CITY OF PORTLAND, MAINE  
DEVELOPMENT REVIEW APPLICATION  
PLANNING DEPARTMENT PROCESSING FORM

2002-0250

103 Herman Island

**CITY OF PORTLAND, MAINE  
DEVELOPMENT REVIEW APPLICATION  
PLANNING DEPARTMENT PROCESSING FORM  
ADDENDUM**

SITE PLAN  
 1

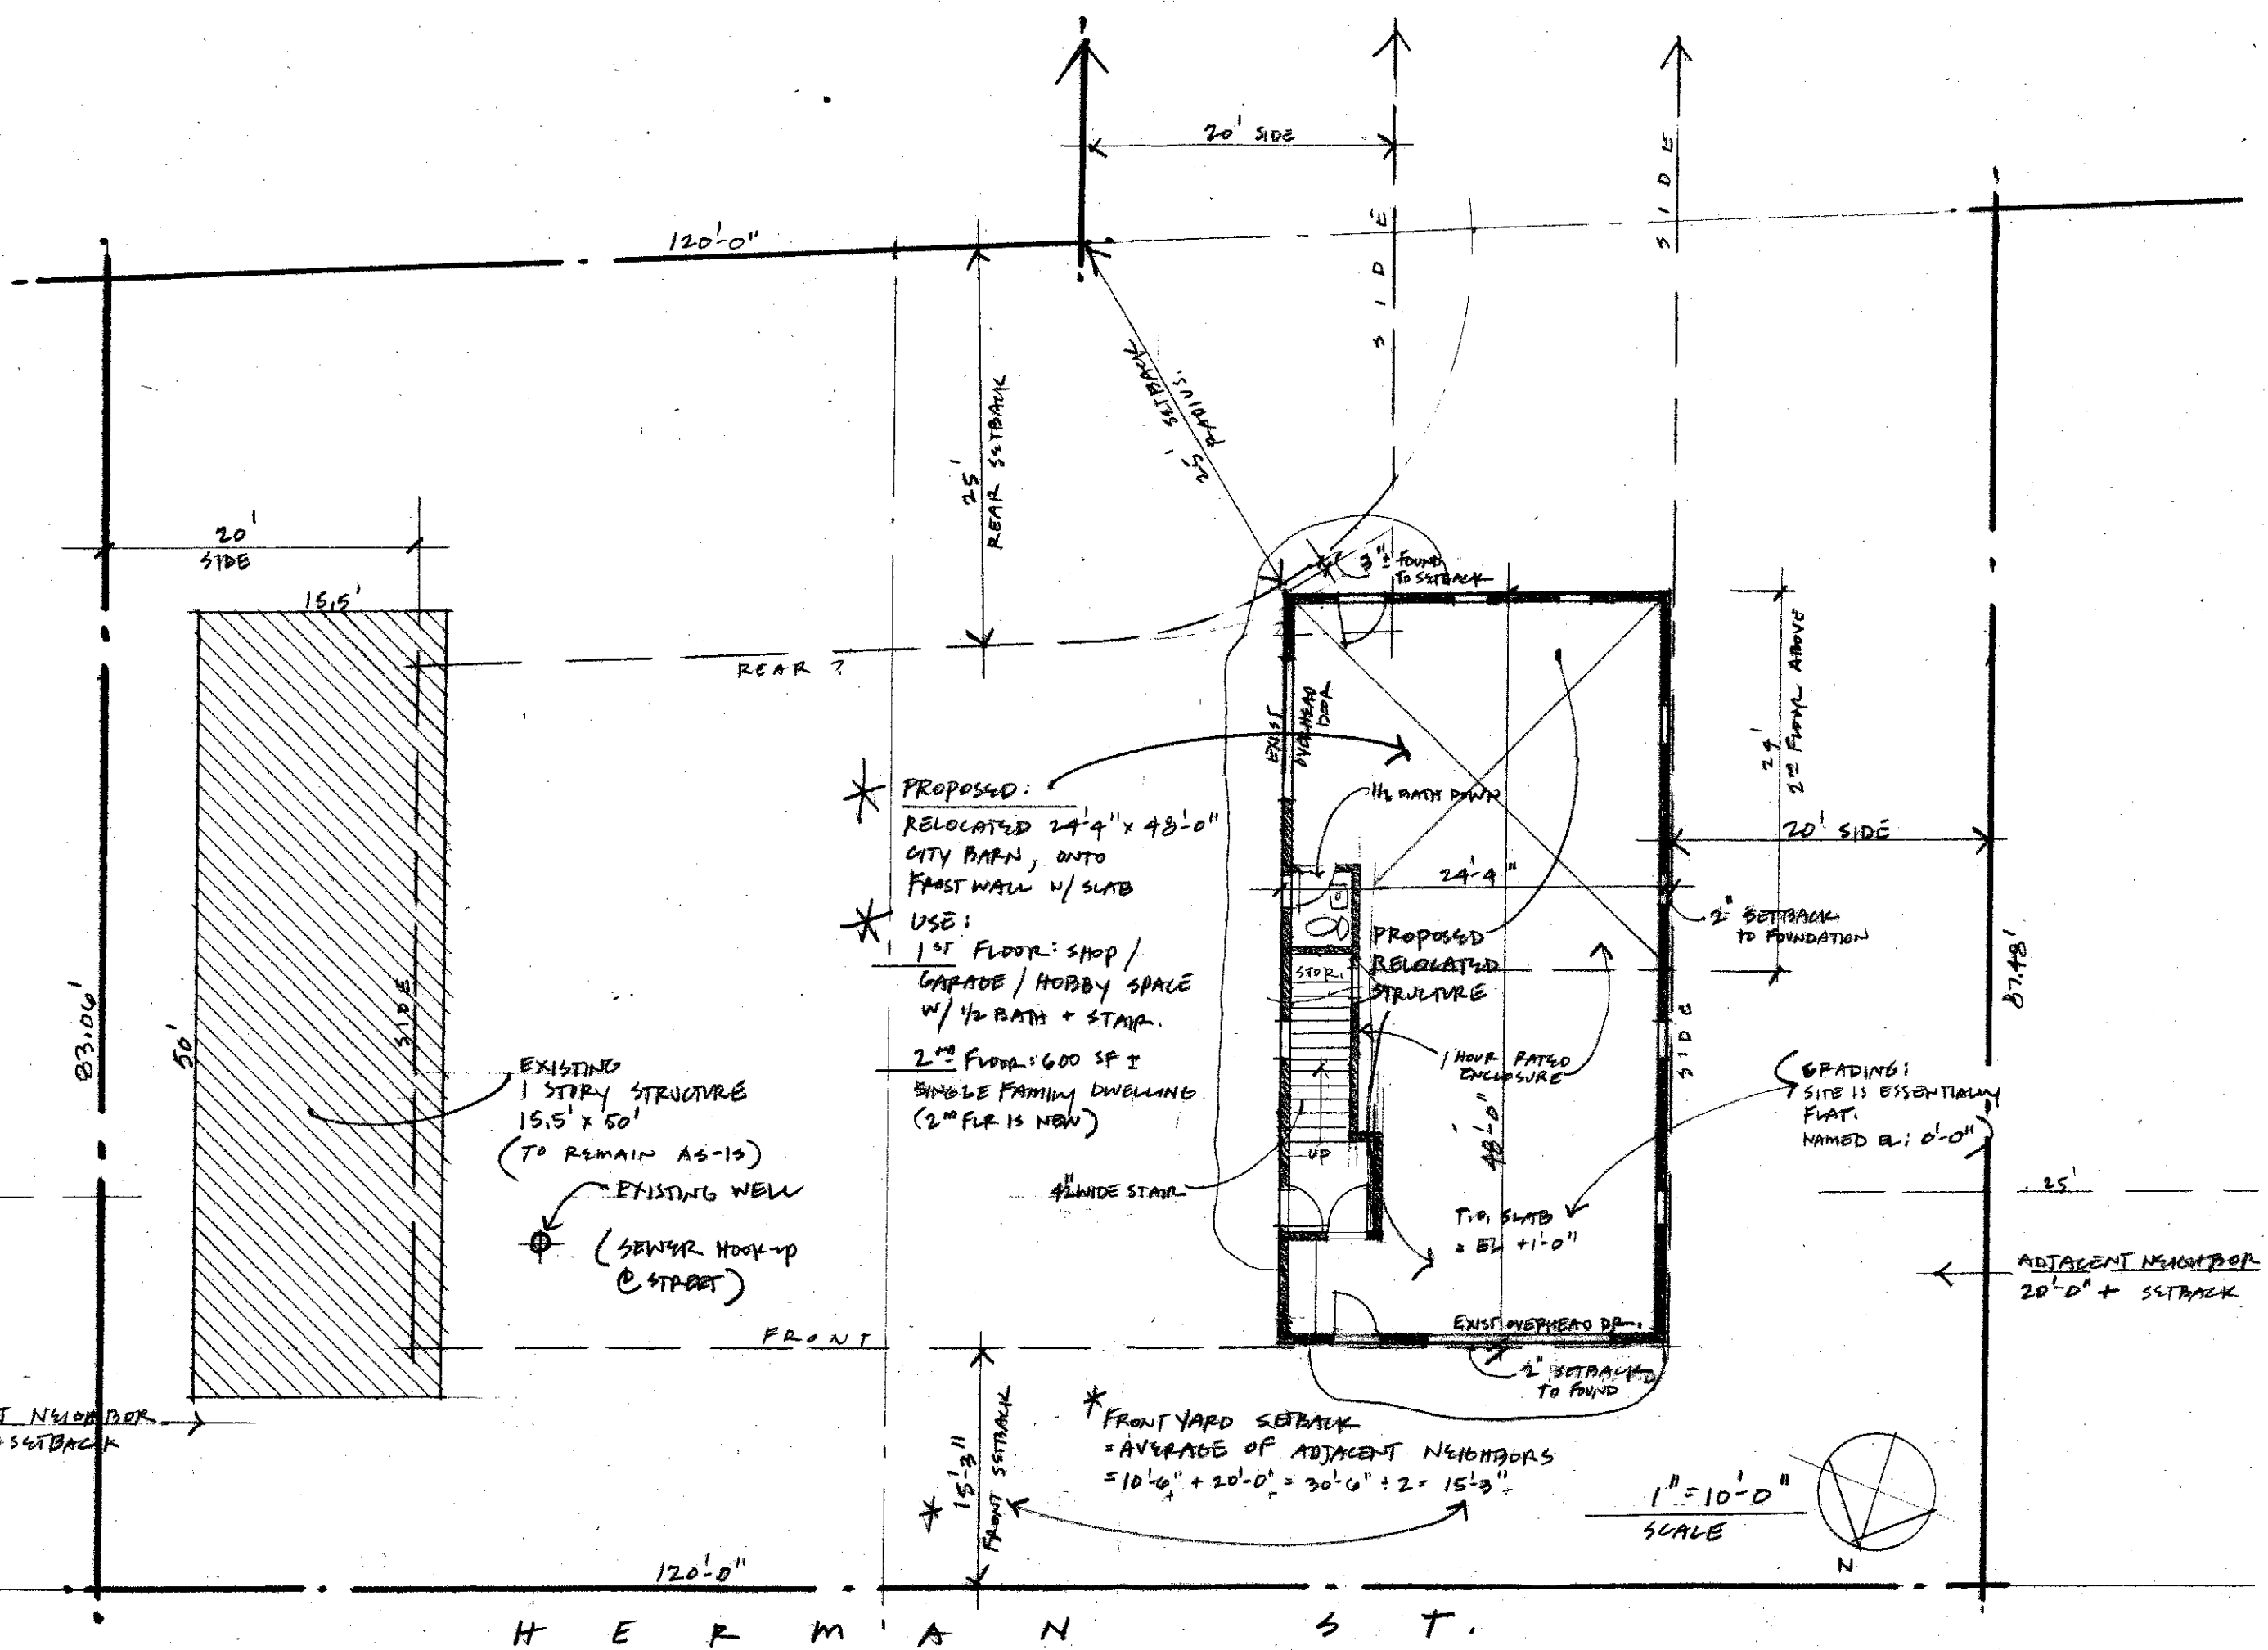
ex. / Prop. Grades (none proposed)  
Does NJ own All Panels  
Snow Well + Sewer + Water Services  
2 street trees  
IS MAKE All Lot w/ Sidewalks +  
Water - Water Lot Line?  
Called Gwilym 1-02-03

- 8 The site contractor shall establish finish grades at the foundation, bulkhead and basement windows to be in conformance with the first floor elevation (FFE) and sill elevation (SE) set by the building contractor to provide for positive drainage away from entire footprint of building.
